December 8, 2022

**Project Location: Arby's Site Development Plan @ South Academy Highlands
4456 Venetucci Boulevard
Colorado Springs, CO 80906**

This letter is in response to the comments received August 12, 2022 regarding the Arby's Site Development Plan application submitted on July 21, 2022.

1 EAST ELEVATION
 1/4" = 1'-0"

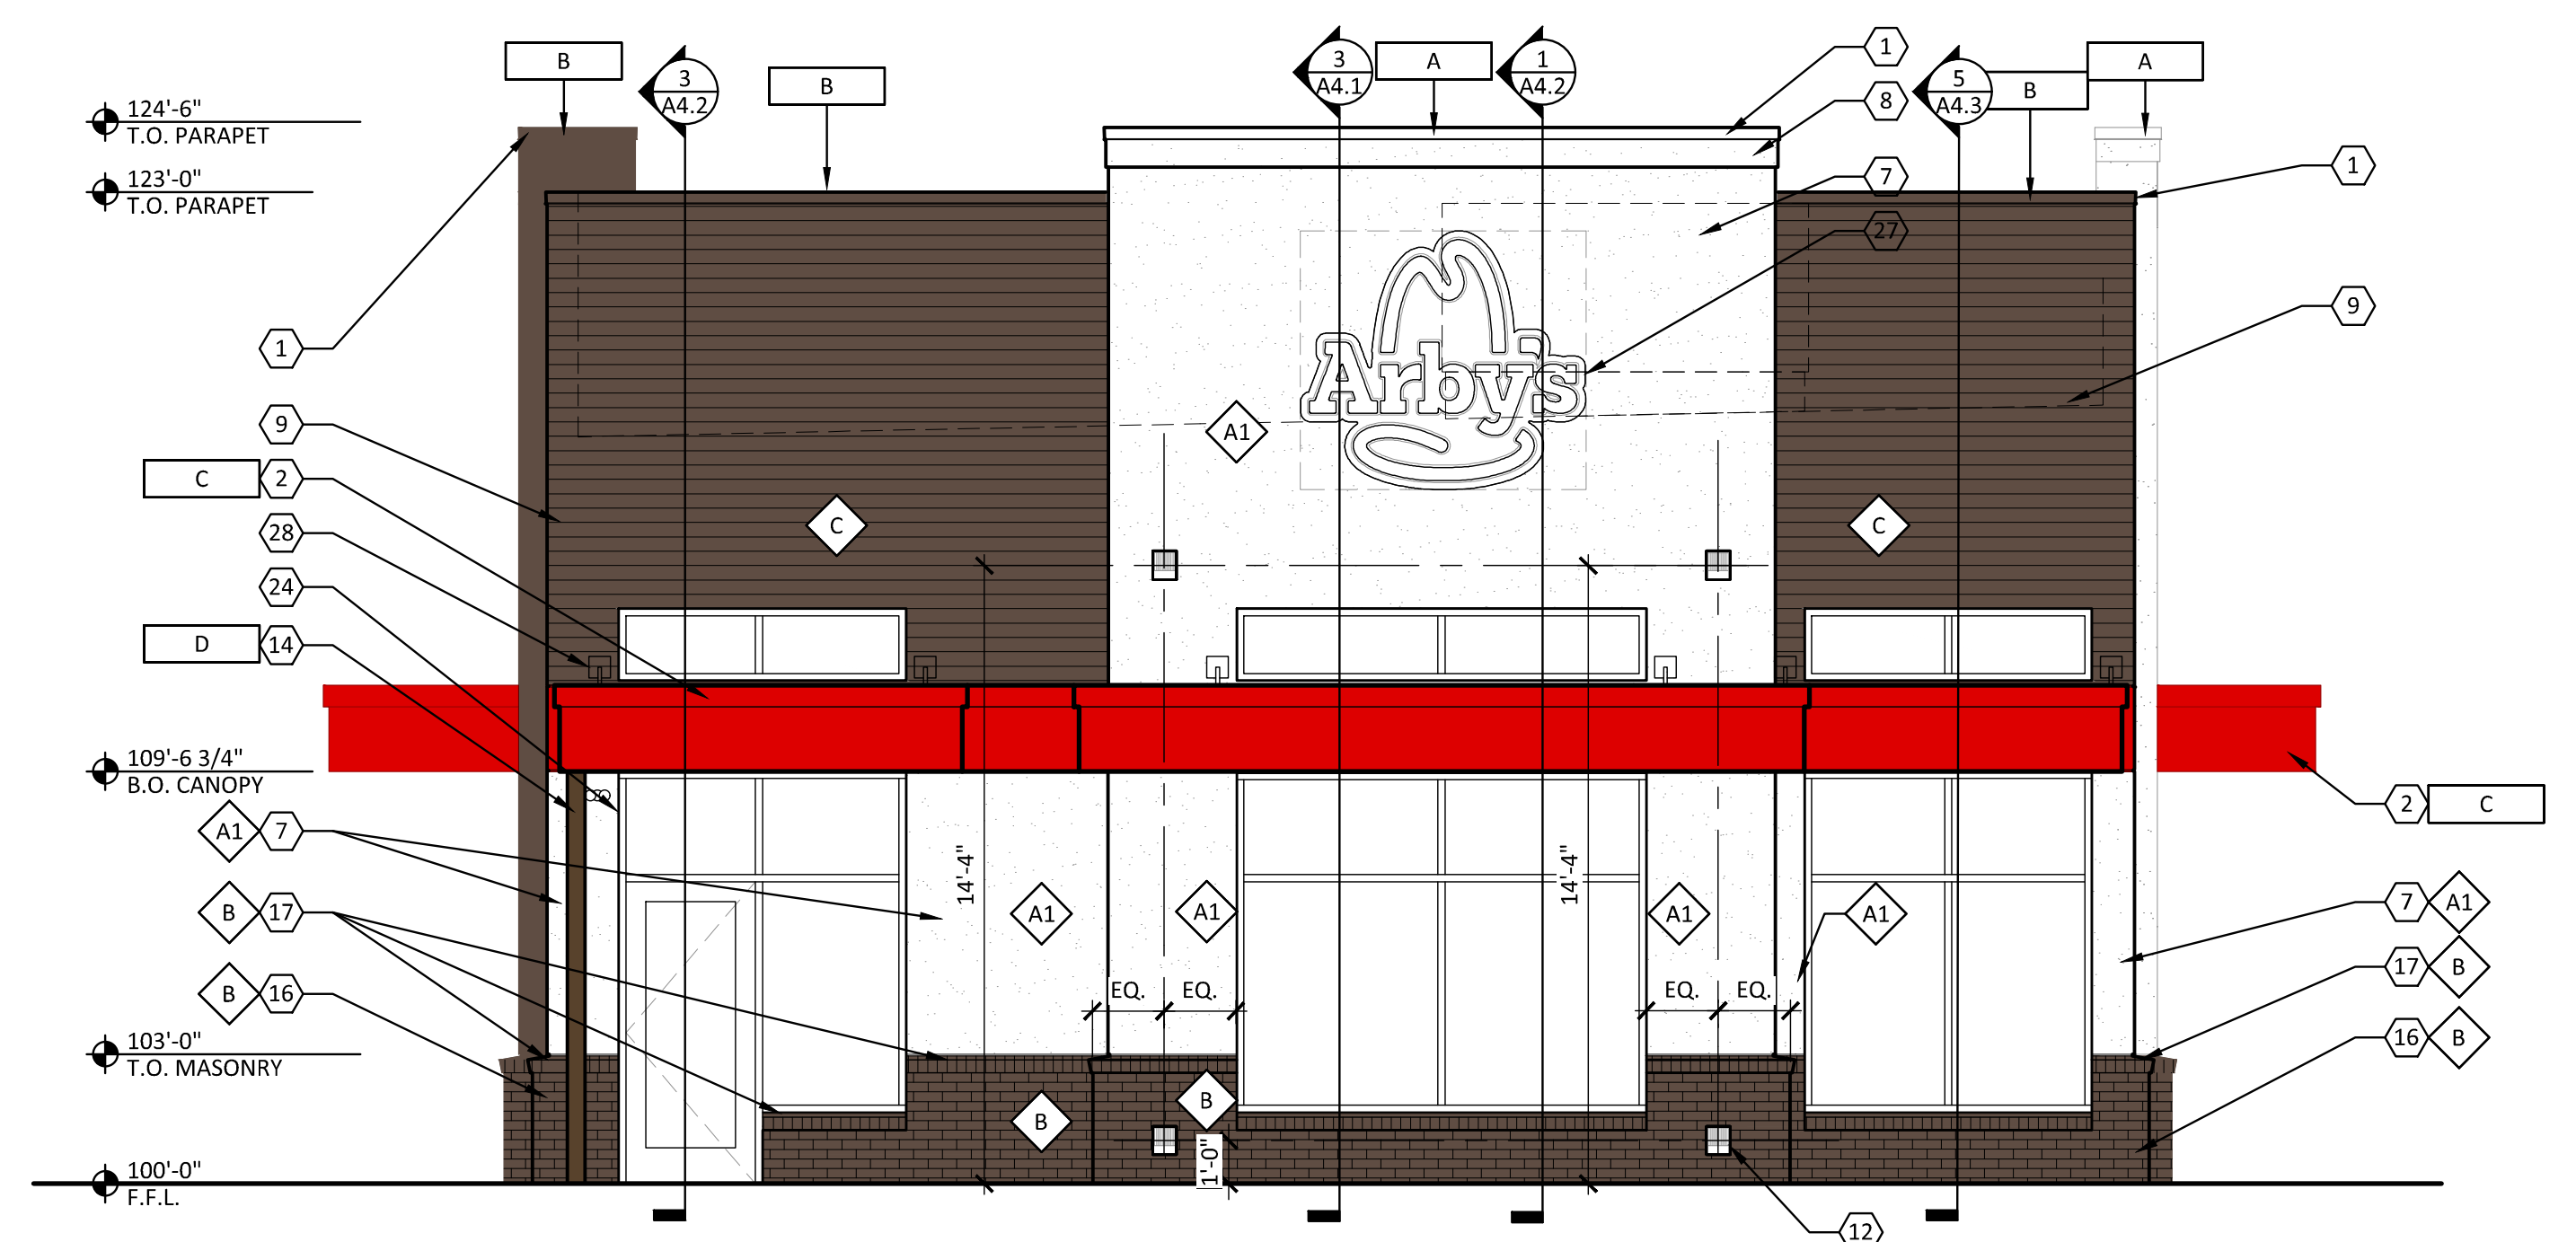
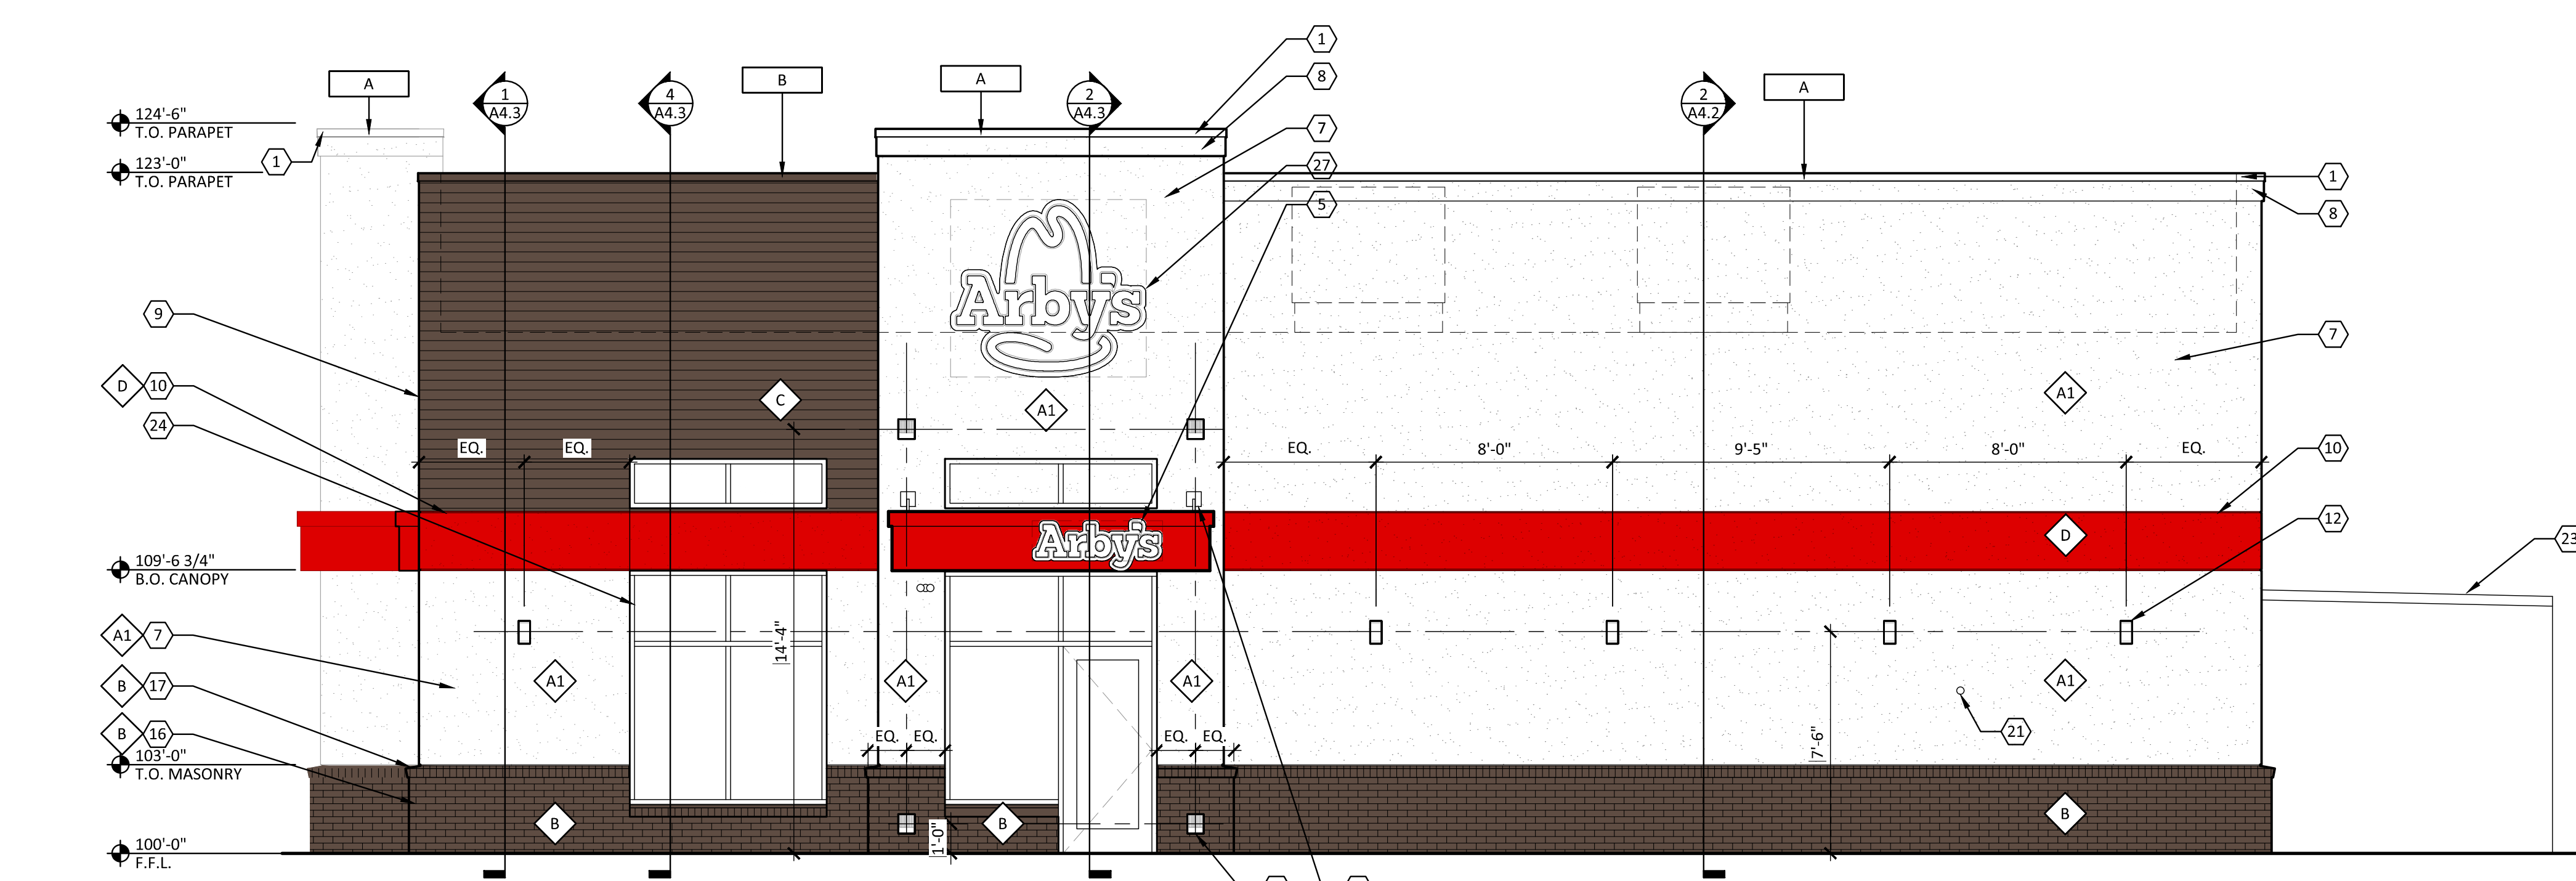
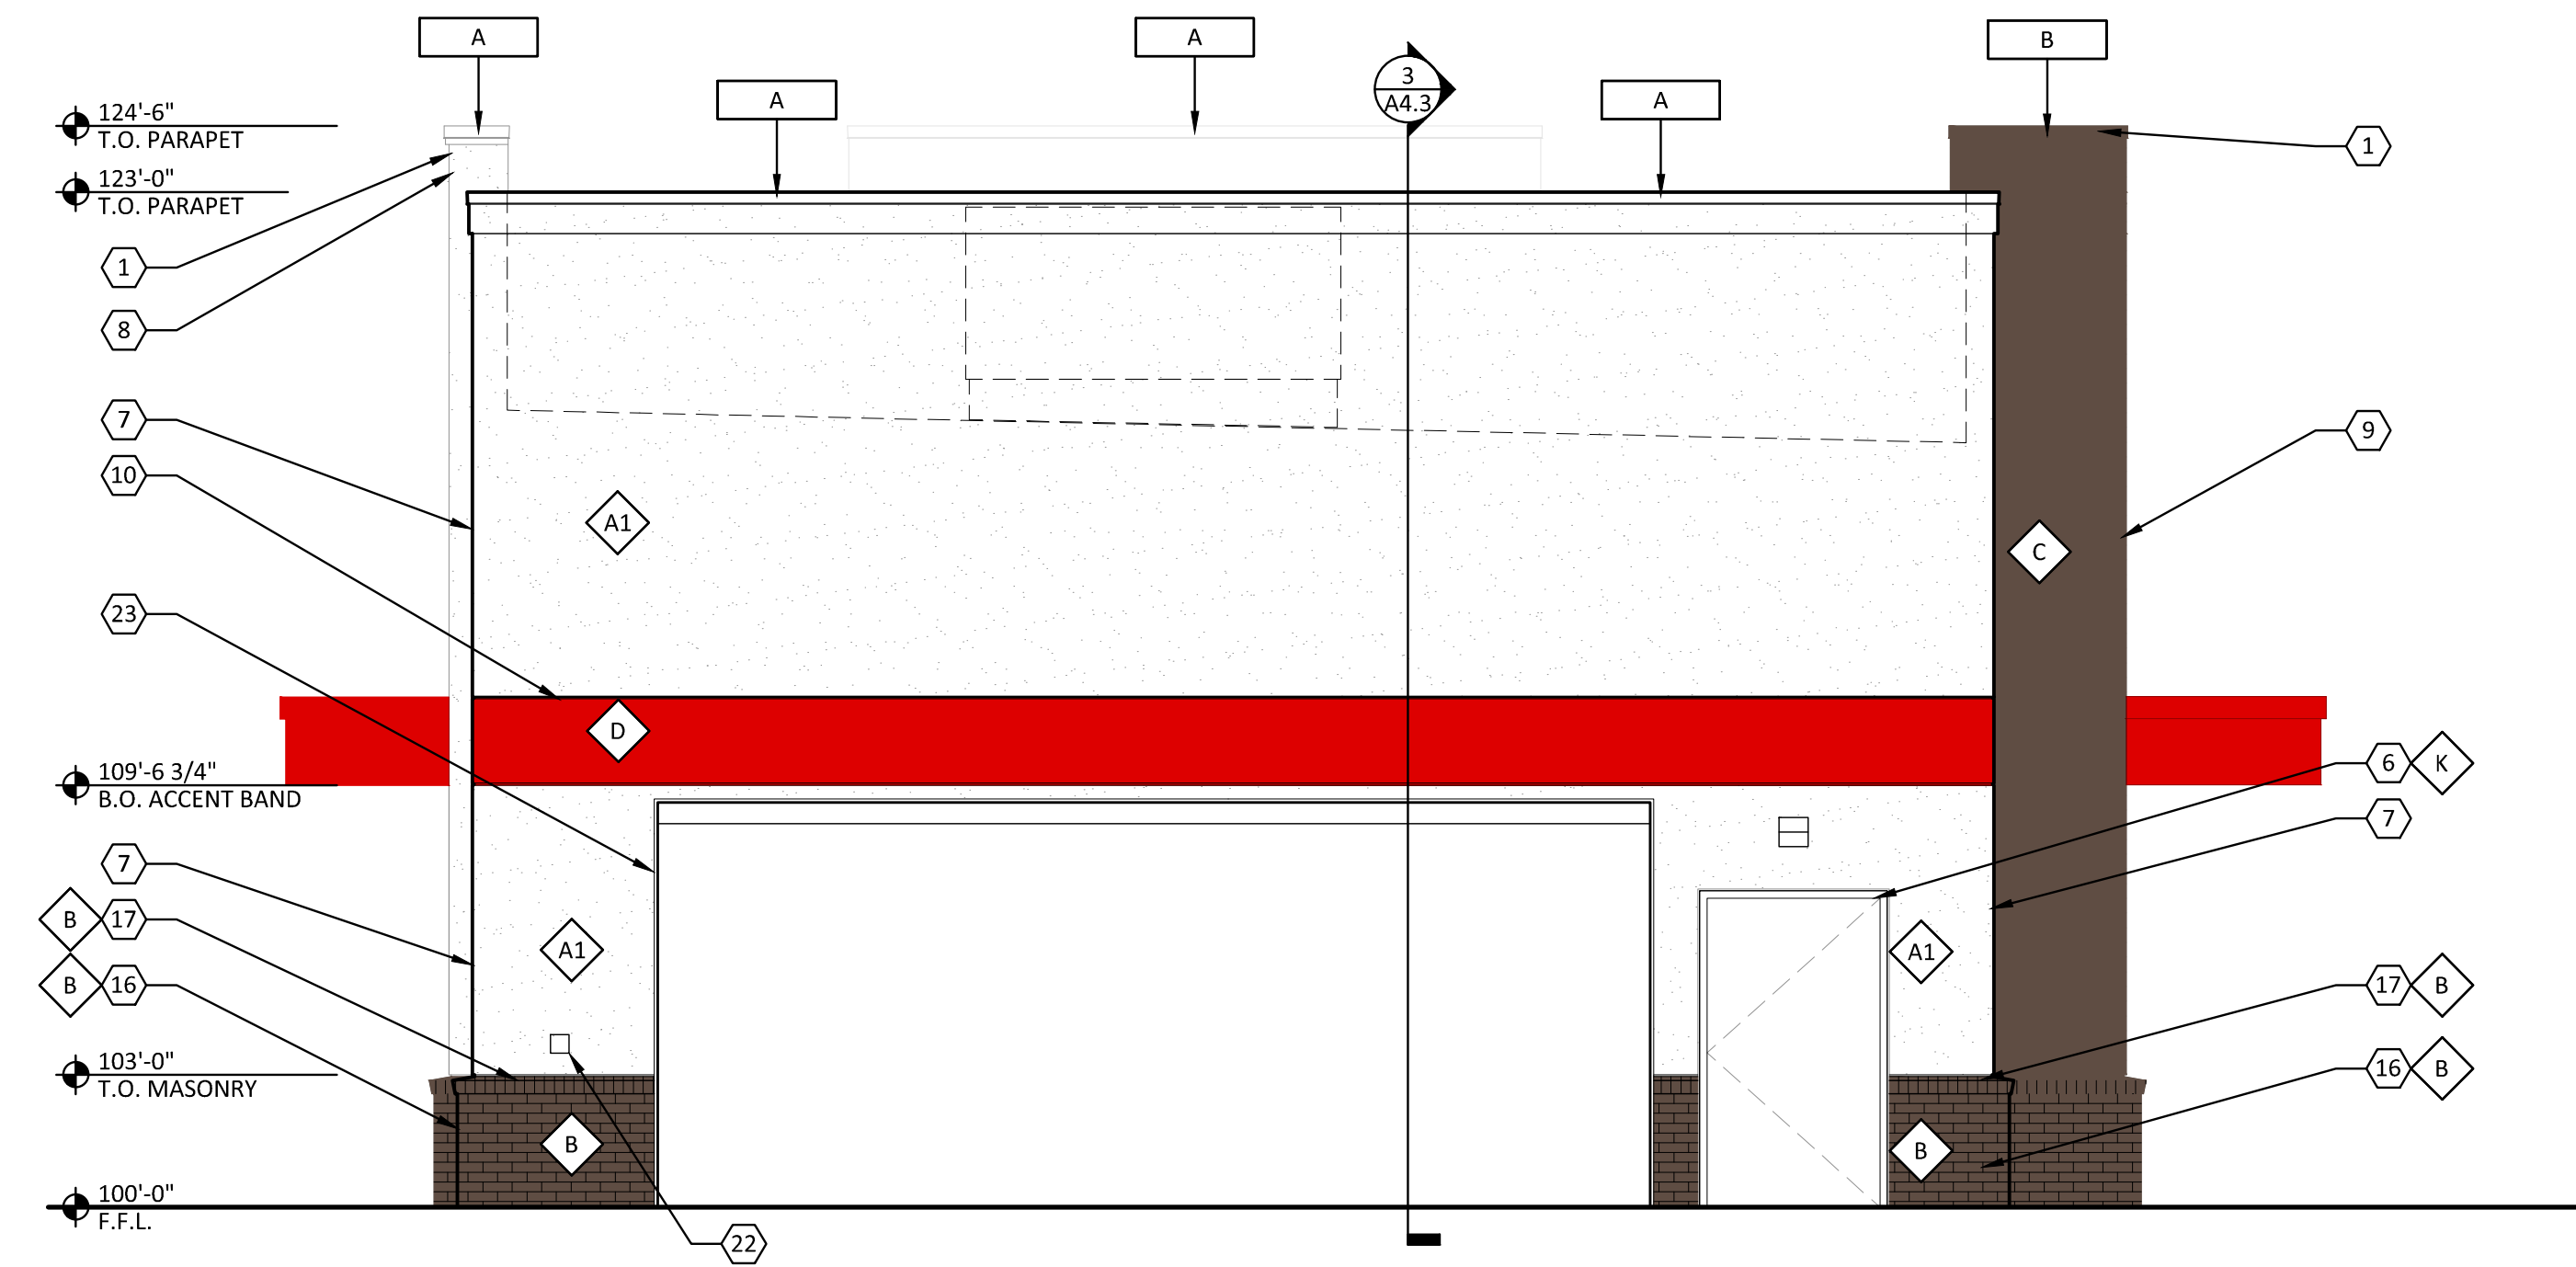
1. Please add the following note: Note: Signage is not reviewed as part of the site development plan and will require a separate sign permit application.

Response: The note has been added. See Sheet A2.1.
